PINS REFERENCE NO: EN010168

DESCRIPTION: Development consent to construct, operate, maintain and decommission a solar photovoltaic (PV) generating station, with a generating capacity of more than 50 megawatts (MW) and associated infrastructure

LOCATION: Lime Down Solar Park, Wiltshire

This response comprises the Cotswolds National Landscape Board's ('the Board's') Written Representations for submission at Examination Deadline 5- 7 August 2026. These representations are made in response to the Examining Authority's Second Written Questions ('ExQ2').

Title:
Figure 3-2-1: Key Construction Phase Features
Lime Down A

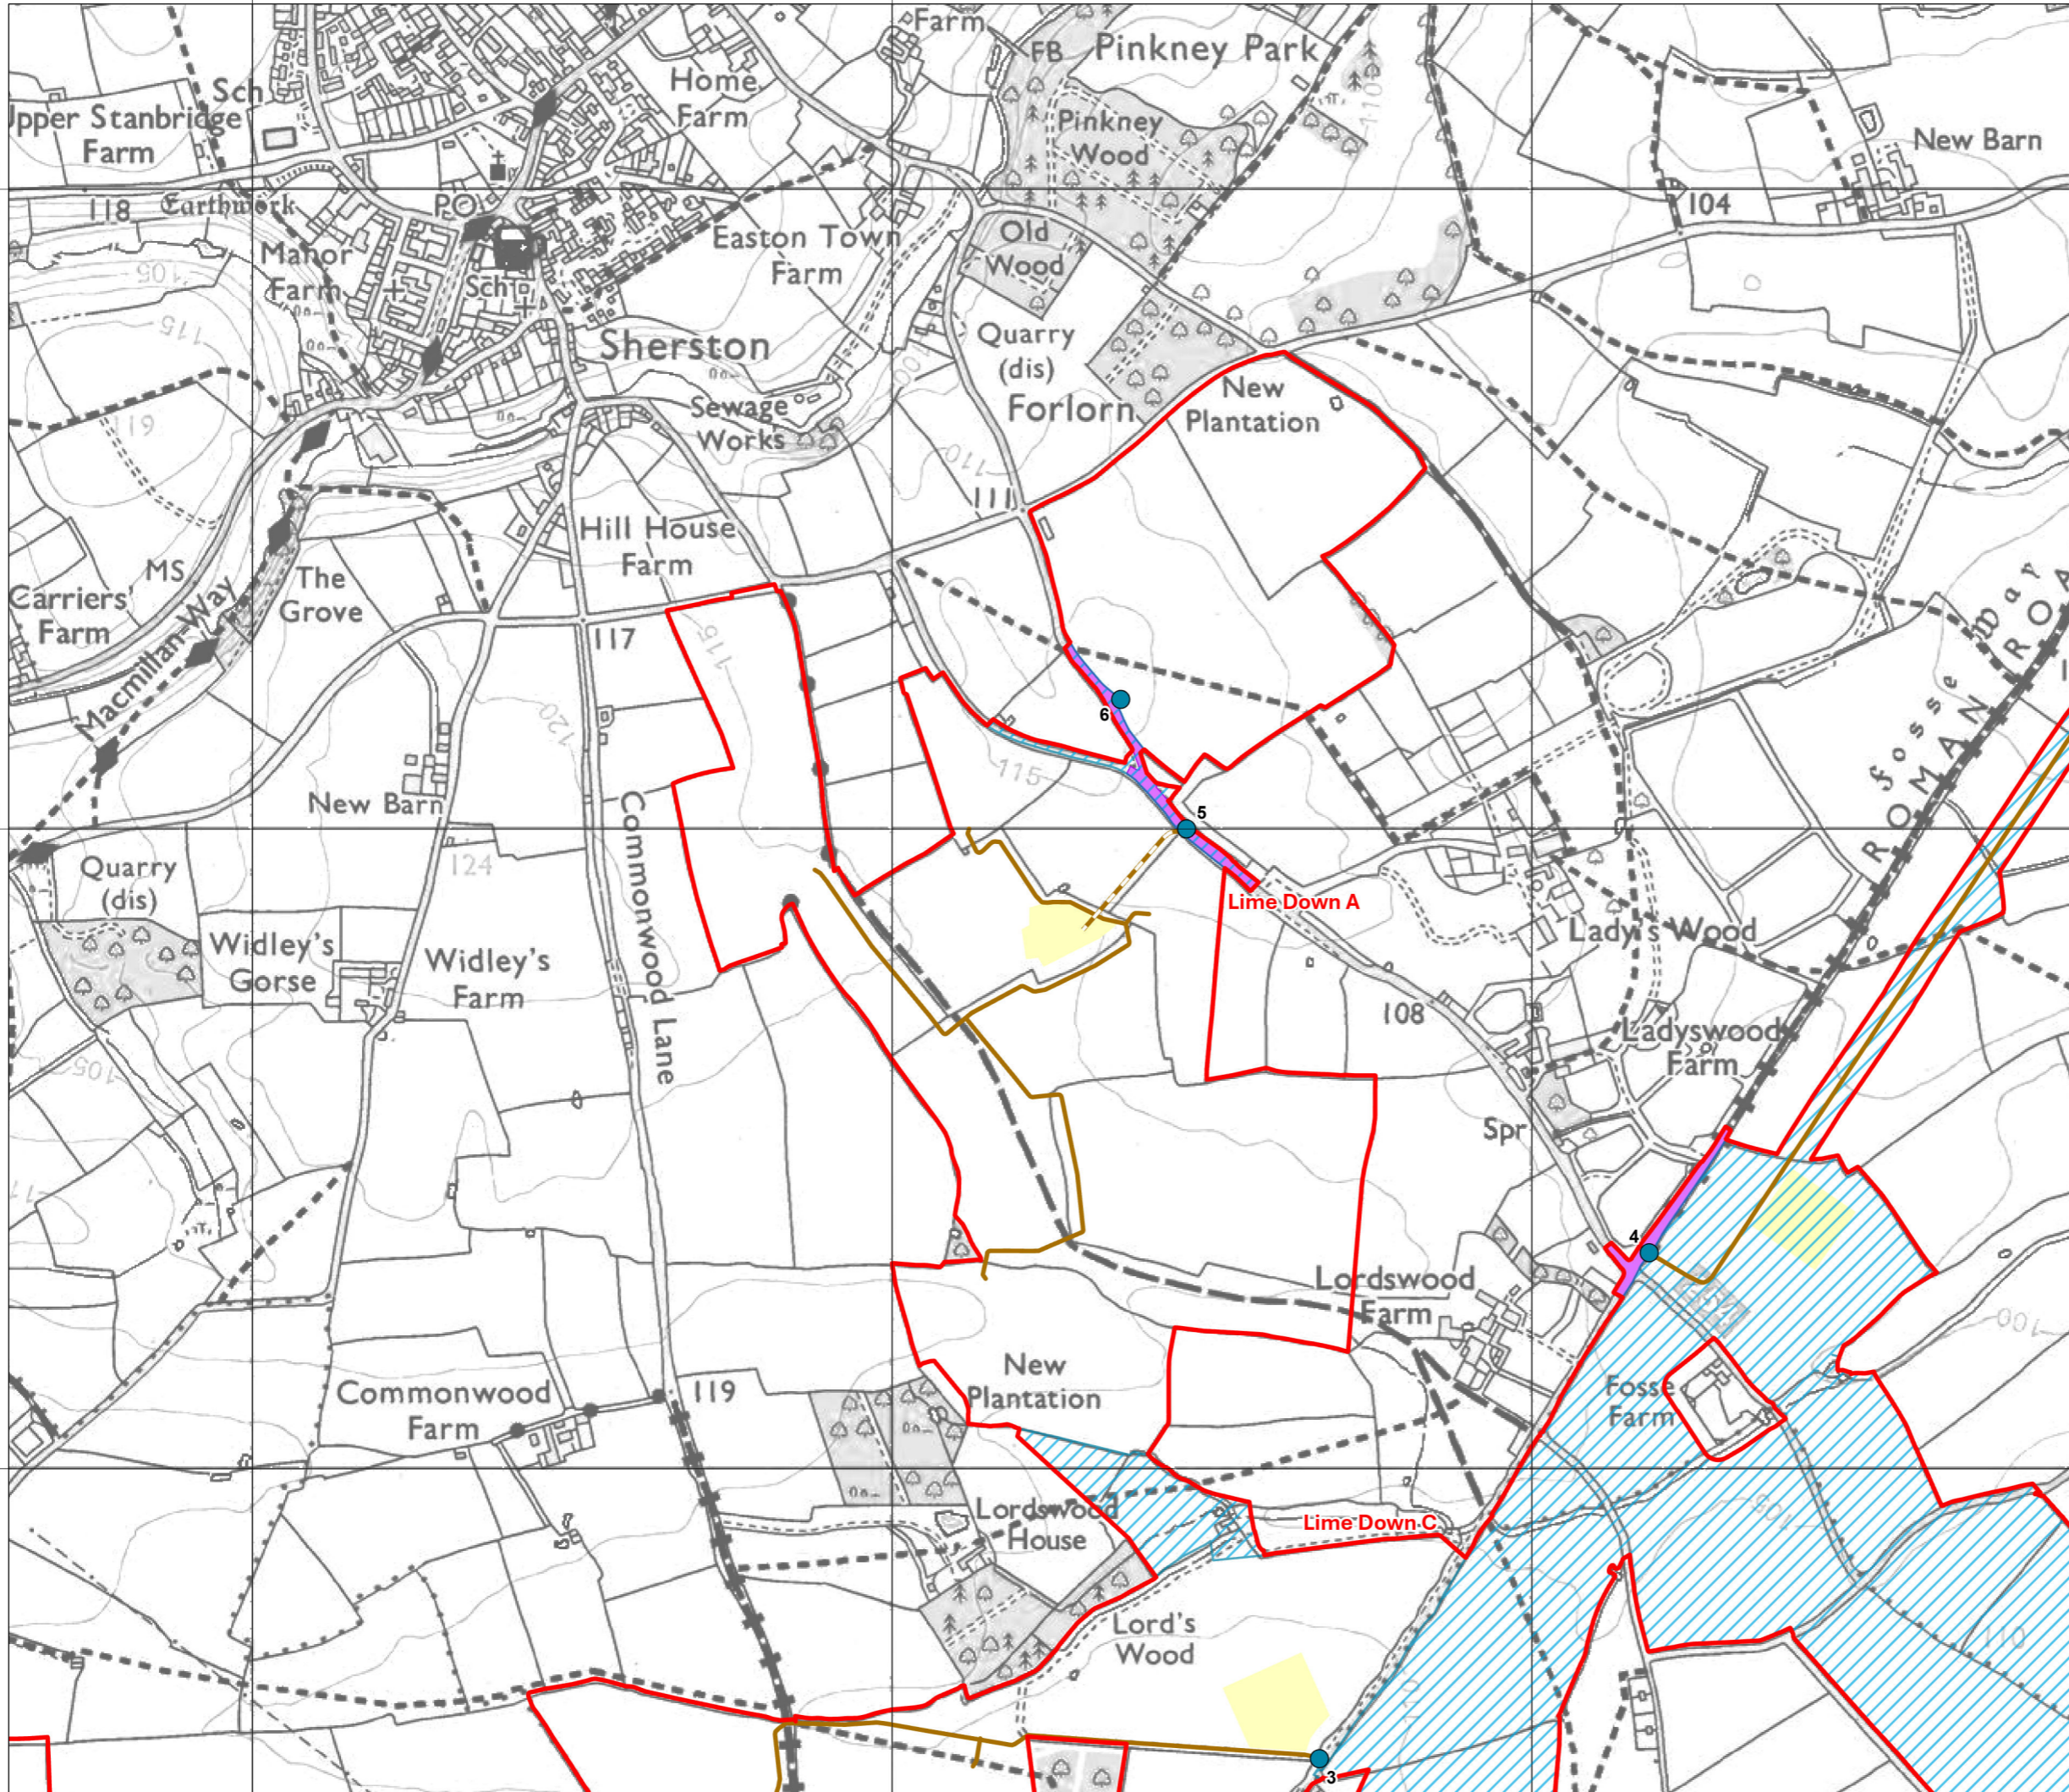
2) The Board had understood that the Scheme included the avoidance of panels in southern part of field A1, however the applicant stated at the Examination Hearing ISH2 that this was a typographical error in the draft Statement of Common Ground with the Board. The latest iteration of the Works Plans [REP3-004] show that the southern part of field A1 is proposed to feature solar panels.

Having reviewed the Works Plans and photomontages provided by the applicant, the Board does not support the location of panels within the southern part of Field A1 and recommends that they should be removed from the scheme.

At its closest point, the area proposed to feature panels would be around 300m from the boundary of the CNL. The key viewpoint in this regard is Viewpoint 6 at the junction of the bridleway which runs along the eastern edge of Field A1, the unnamed road that marks the boundary with the CNL and Bustlers Hill. The northern part of Field A1 is proposed as wildflower meadow, however this would not aid in screening the development from this viewpoint and therefore the only screening between the receptor and the panels would be a narrow belt of new planting across the middle of Field A1 which in itself would comprise an artificially created boundary as there is no current boundary planting or features between the northern and southern parts of the field.

The REV 3 photomontages provided by the applicant at Deadline 2 [Figure 8-14-6, REP2-010] show that the panels in the southern part of Field A1 would be highly visible in Year 1 from the boundary with the CNL (Viewpoint 6) and also likely for a significant length of the bridleway running south from the CNL boundary along the field edge. The panels would remain visible at Year 15 through the screening in wintertime and would possibly also be visible in summer at Year 15 for receptors travelling along the bridleway past the site on journeys to or from the CNL.

Compared to the baseline situation of an arable field devoid of development, locating panels in the southern part of Field A1 would in our view give rise to major adverse residual visual effects at Year 1 and moderate adverse residual visual effects at Year 15 (i.e. significant at both Year 1 and Year 15). Accordingly, the Board recommends that panels should be removed from the southern part of Field A1 to conserve and enhance the landscape and scenic beauty of the CNL and its setting.
